Norfolk Gliding Club Ltd

Norwich to Tilbury EN020027

Response to REP2-029

Figure 1.4 Tibenham

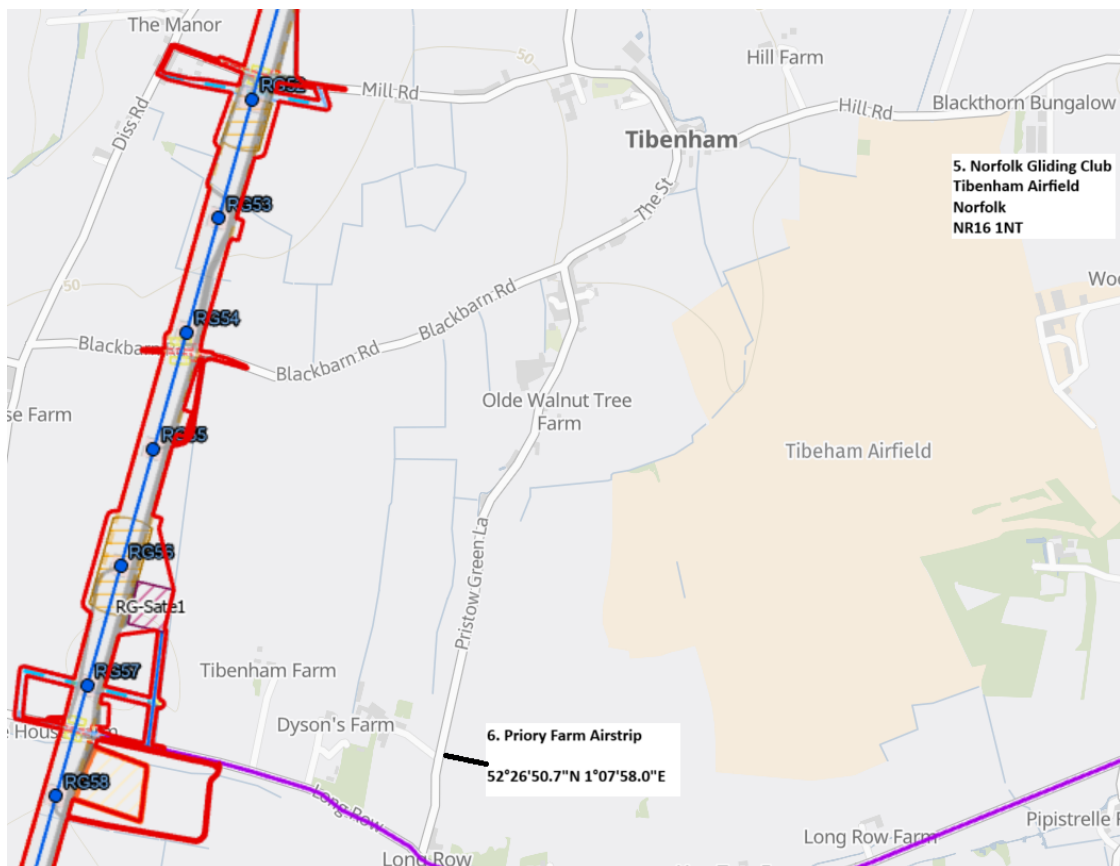
The proposed pylon route represents a 200ft electrified wall cutting off 25% of the area covered by Norfolk Gliding Clubs safeguarding zone and only 1,700m from each of the ends of two runways. As such the emergency landing opportunities afforded by the land to the west of those runways would be reduced to a level below the minimums advised by the Civil Aviation Authority making their use unsafe

With respect to the proximity of the proposed route to Tibenham and Priory Farm this would involve the overhead line being realigned to outside our 5km safeguarding zone or undergrounded whilst passing through the zone

The proposed overhead alignment would prevent the safe use of runway 26 for aerotows and the use of runway 08 for competition finishes where the pilots of the higher performance gliders would be crossing the proposed line at 100ft, half the height of the pylons.
